# Planning and Development

Date: 12/09/2024

**Site: Stonestreet Green Solar**  
**Proposal: Application for an Order granting Development Consent**  
**Issue: Relevant Representation**

Project Name:  
 Stonestreet Green Solar  
 Drawing Title:  
 Illustrative Layout Plan  
 Sheet 2 of 5  
 Drawing Number:  
 142-02-01-pg2  
 Scale: 1:2,000@A1 APFP Reg. 5(2)(a)  
 Produced: RC Checked: Quod Date: November 2024 Version: 02

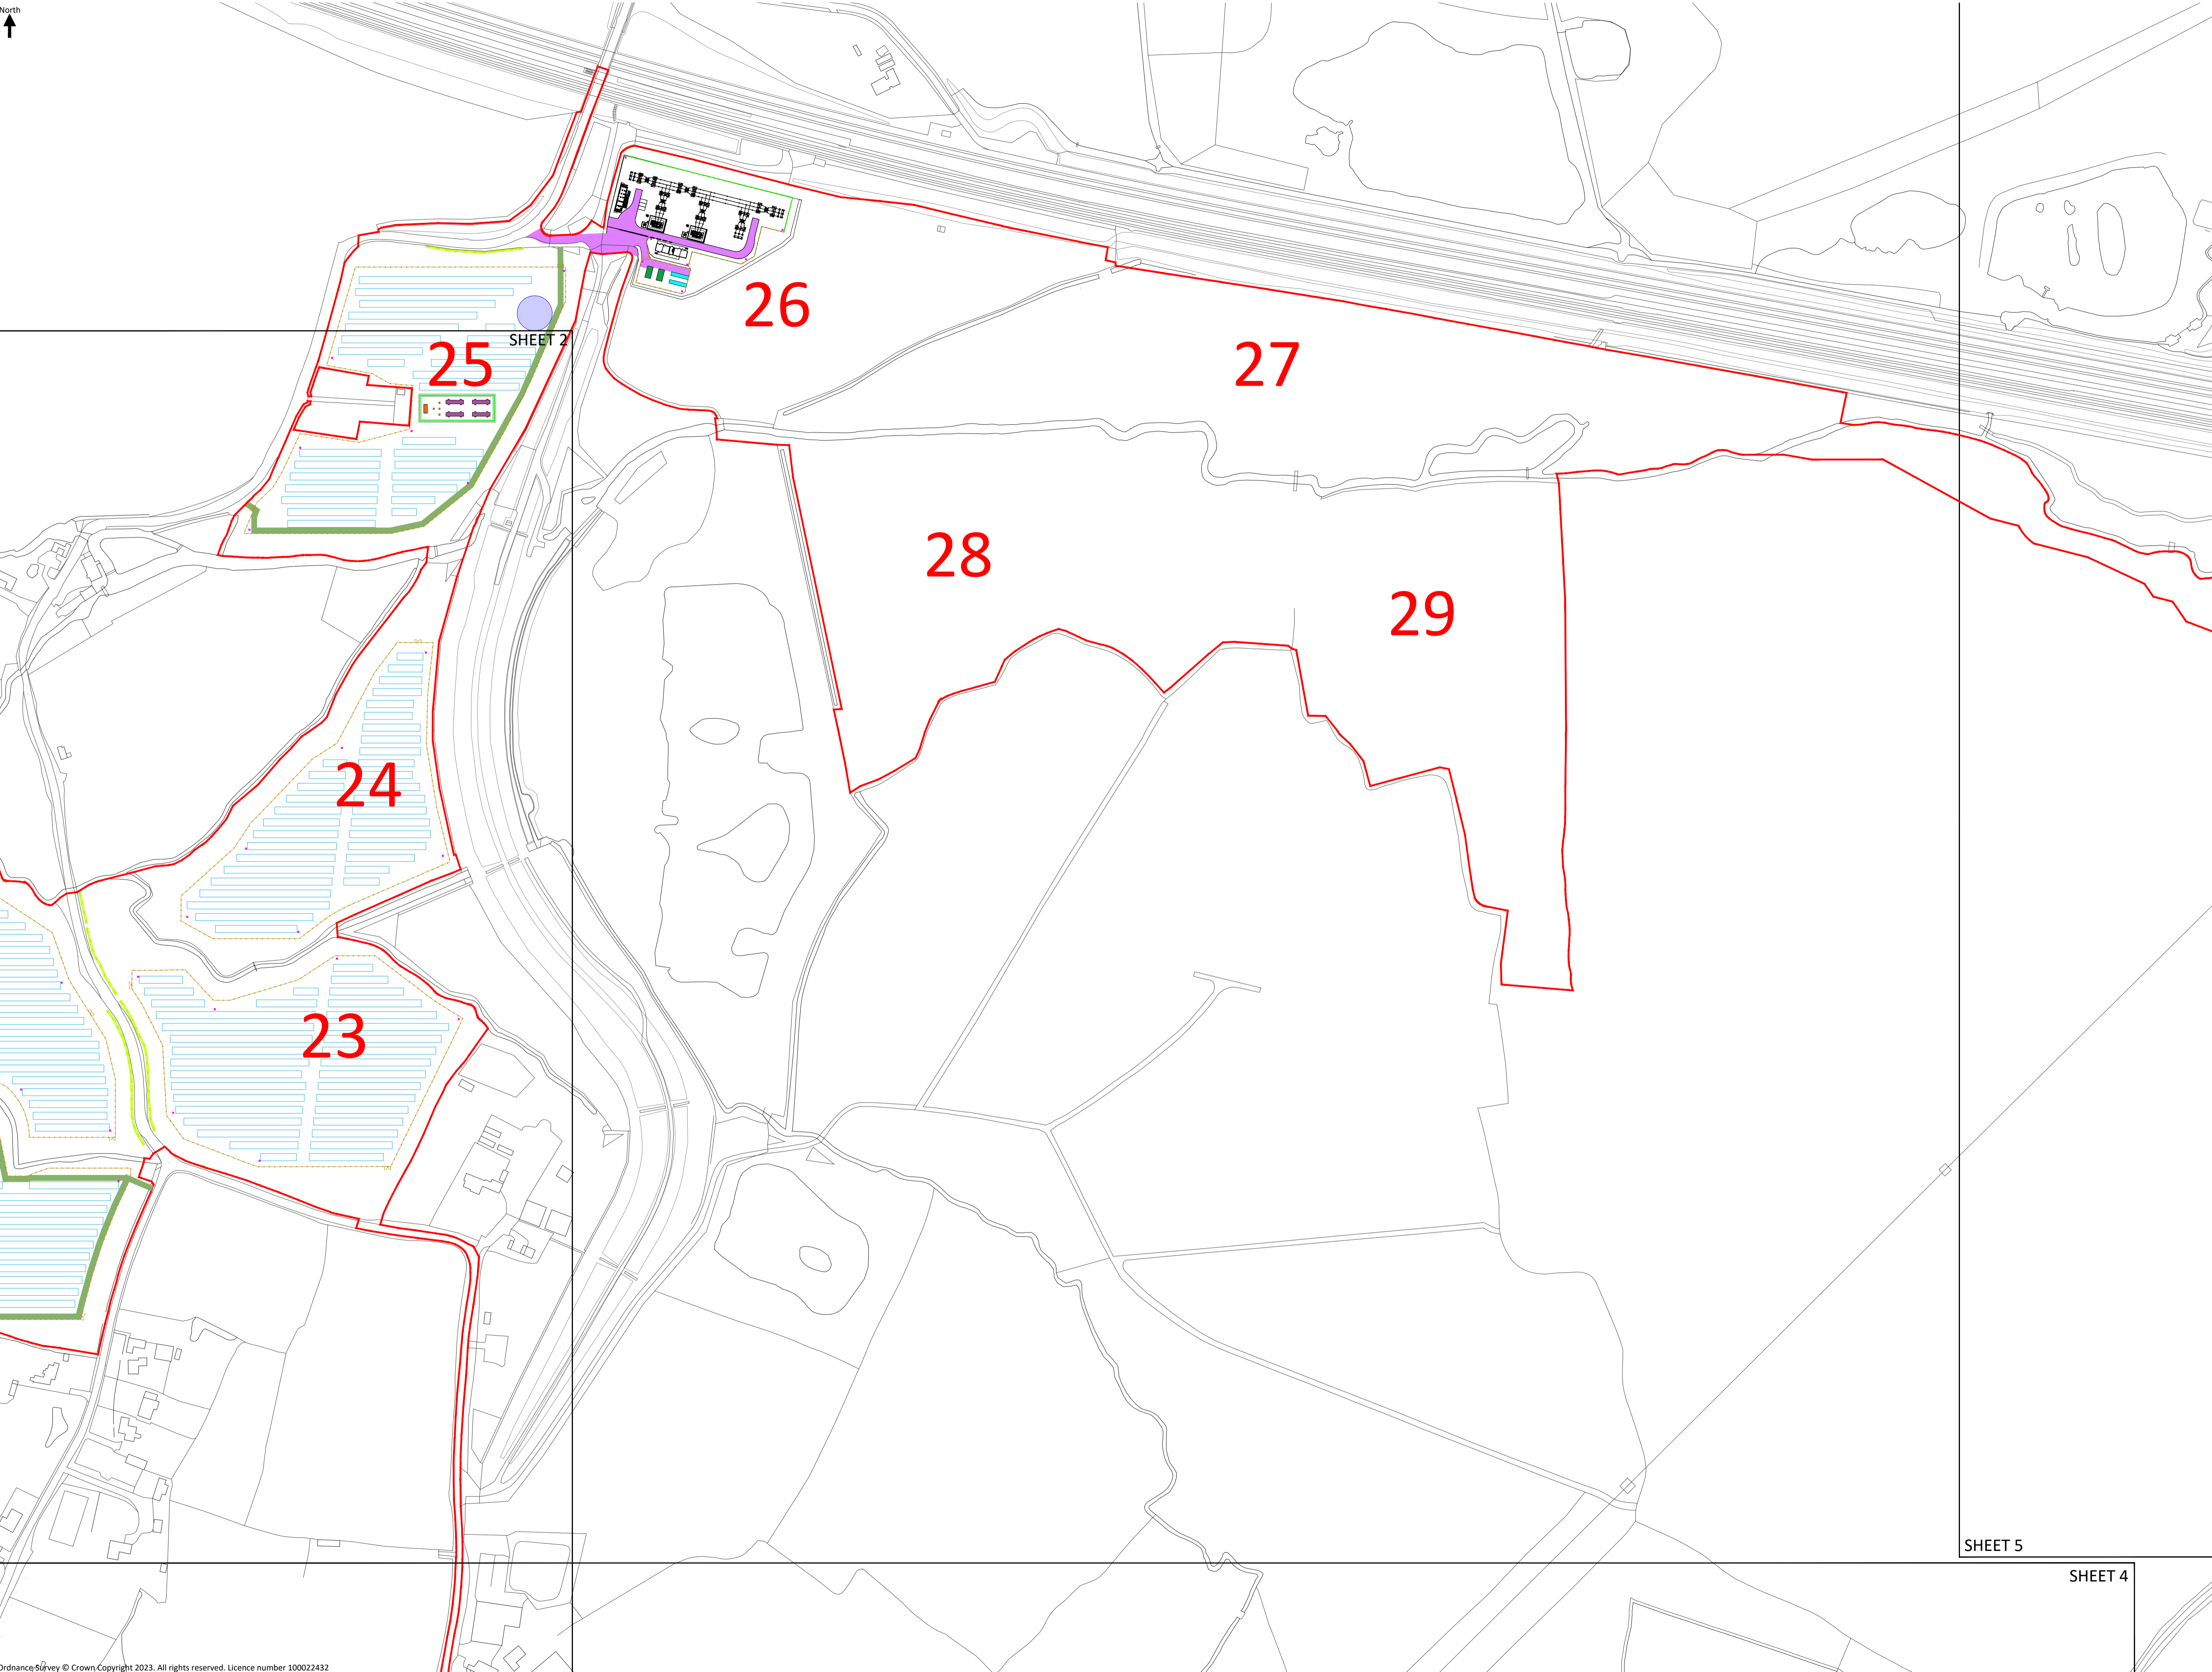
21. The Council consider that tangible material landscape and visual impact benefits would be likely to be achieved if panels were to be removed from fields at higher AOD levels close to this distinctive ridge along which Roman Road / Bank Road passes. The removal of panels from Fields 10 & 12 was therefore suggested to the applicant in this regard.

26. The greater use of tree belts would help break up and reduce the prominence of the mass of panels, in particular in the views that are available from the north. A strong tree-belt on the northern edge of the northern-most Field 19 in this part of the site is appropriate but the Council consider that this needs to work in conjunction with a greater level of new tree planting and associated scheme loosening through fragmentation in the areas south of that northern-most boundary.

of this area is important because the boundary is close to PRow AE474. The Council is concerned that the scheme impacts on the experiential qualities enjoyed by the users of that route. The qualities include the appreciation of a wide area of landscape from a high point as well as a key vista (that includes landscape) towards the Grade 1 listed Church of St. Martin which sits prominently on the east-west Aldington ridge. The Council would wish to see softening and, ideally, solar development and infrastructure pulled further northwards away from PRow AE474.
